Charlotte Storm Water
600 East Fourth Street
Charlotte, N C 28202-2844

Rezoning Petition Review

Date of Review: April 20, 2020 (***Revised May 18, 2020***)

Rezoning Petition #: 20-38

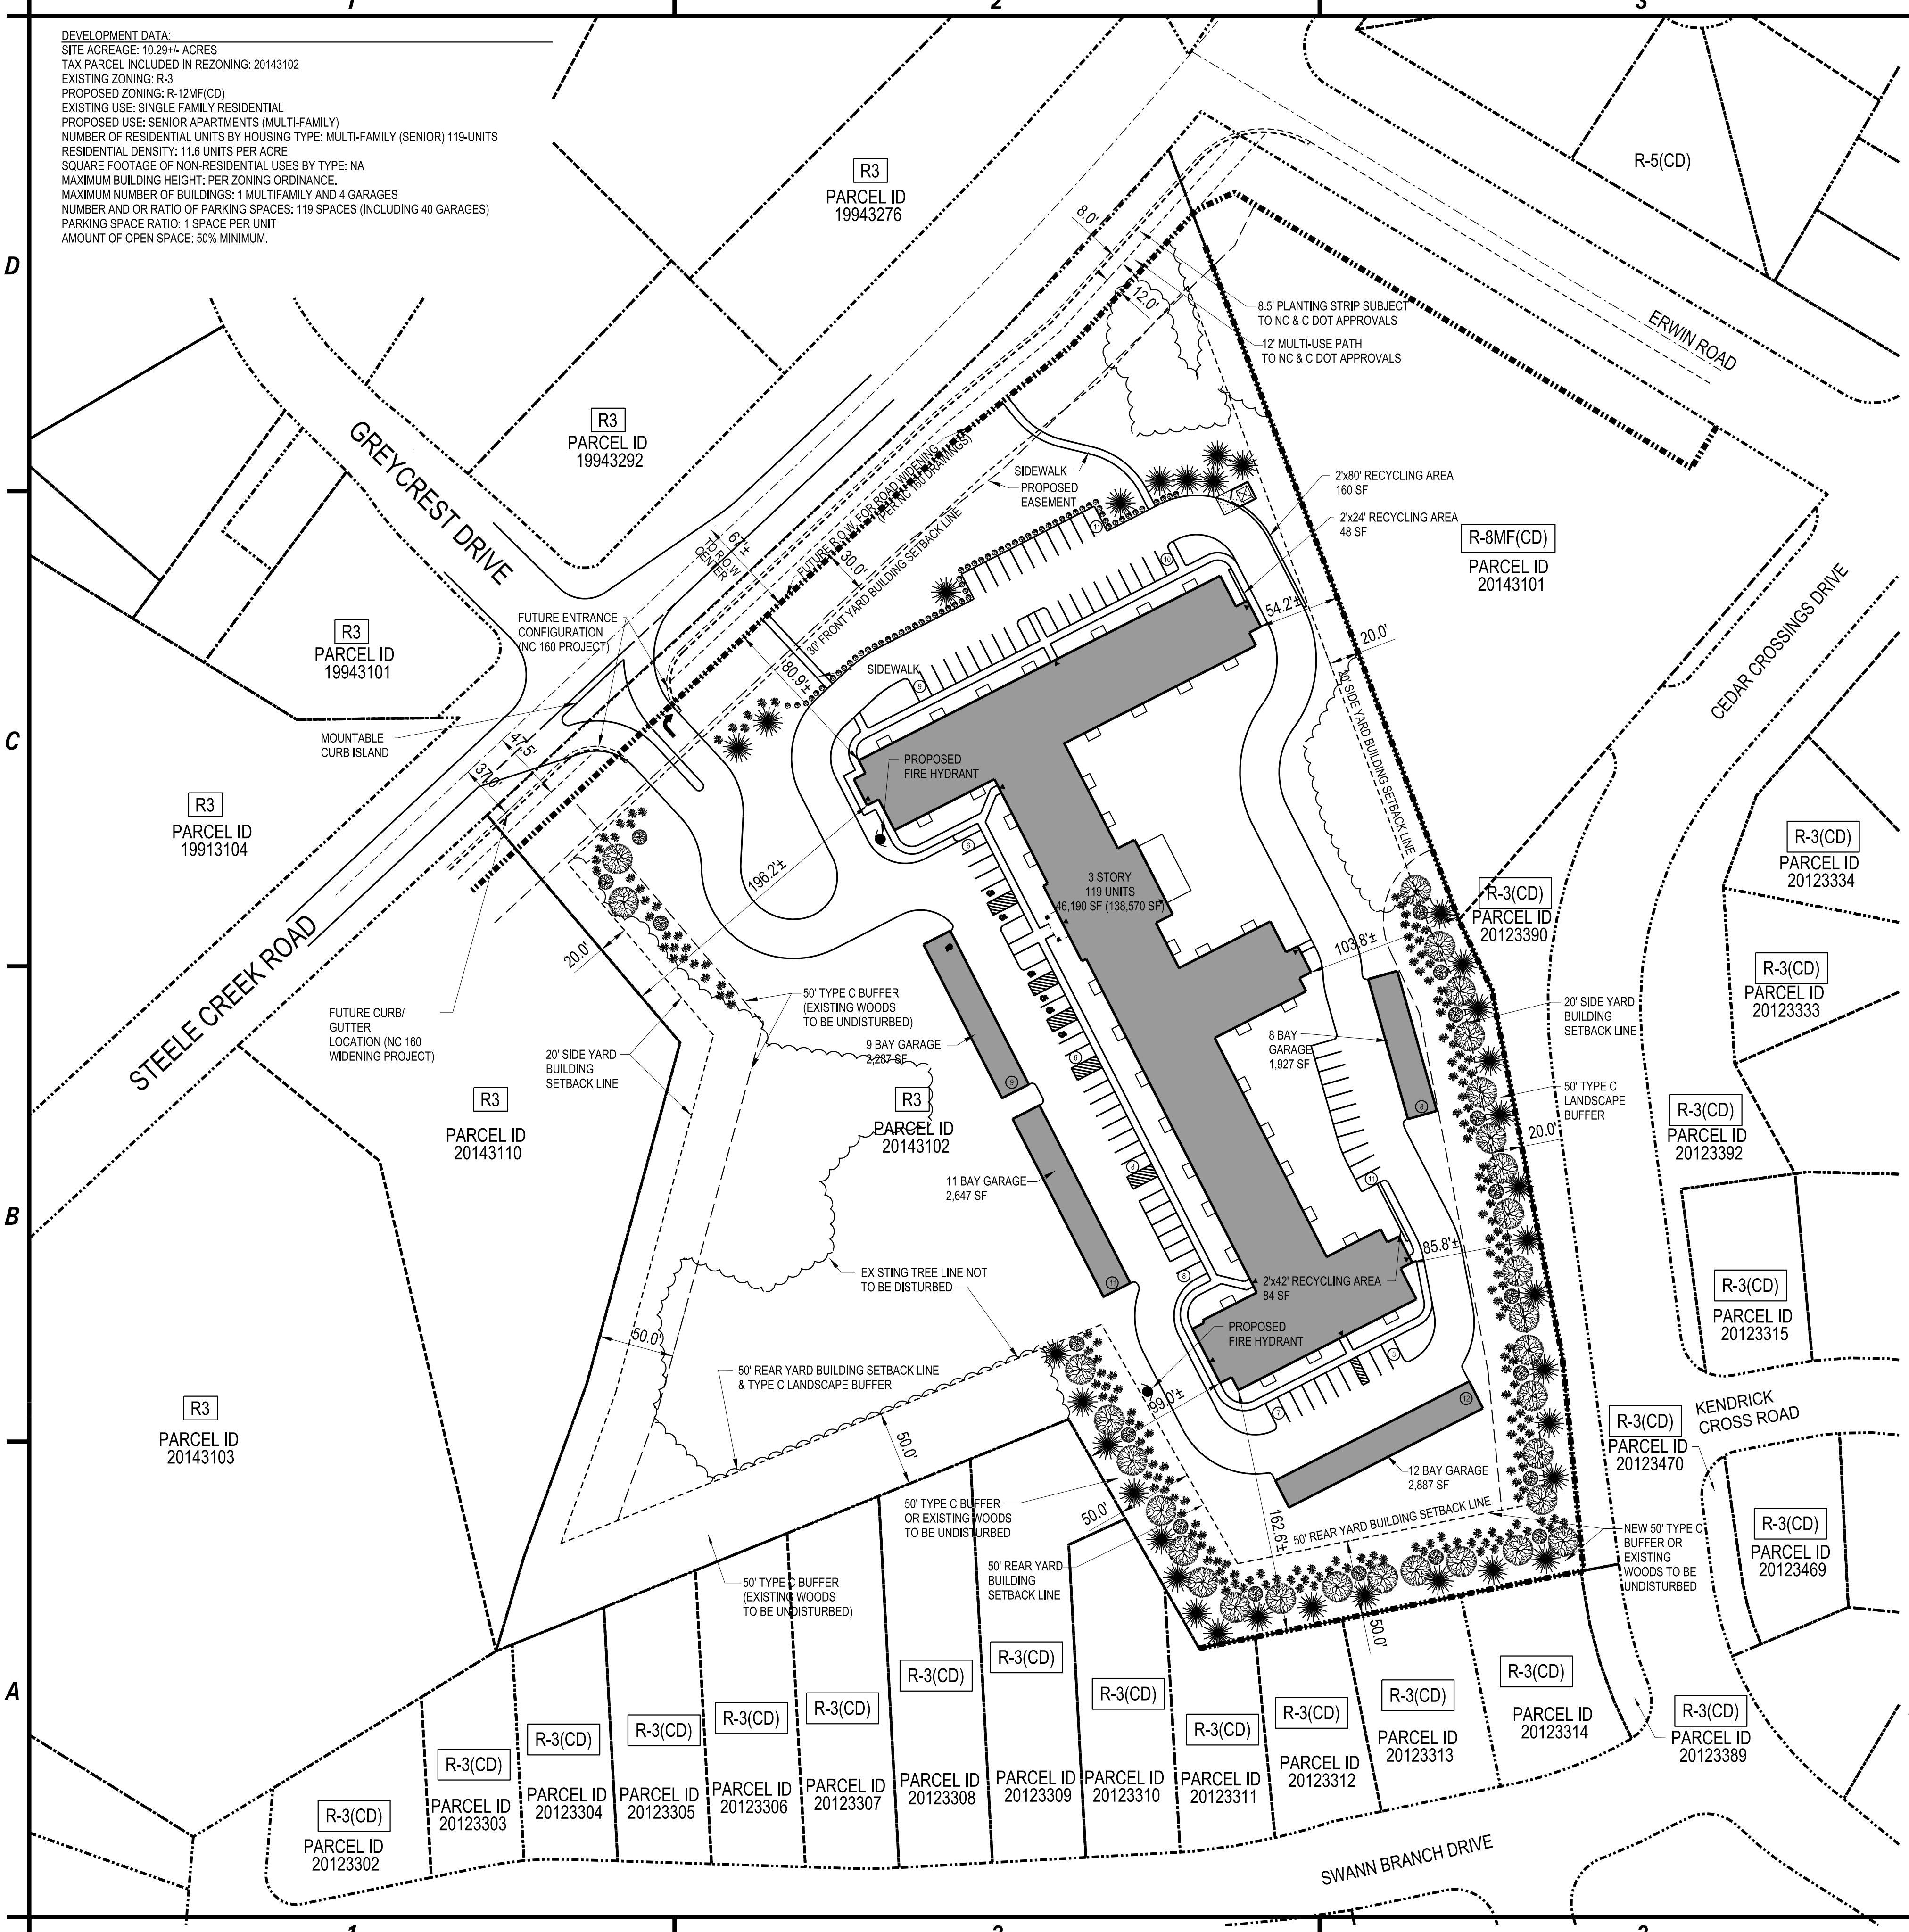
Concerning Storm Water: Please include the following note under Environmental Features. *For adjoining parcels receiving storm water discharge the petitioner shall analyze the adequacy of the existing storm water conveyance on the adjoining parcels to the downstream channel (identified by the SWIM/PCSO buffer on PID 20143103). If the existing storm water conveyance on the adjoining parcels is found to be inadequate, the Petitioner shall make a good faith effort with the property owner(s) to improve the storm water conveyance or mitigate the storm water discharge onto the adjoining parcels.*
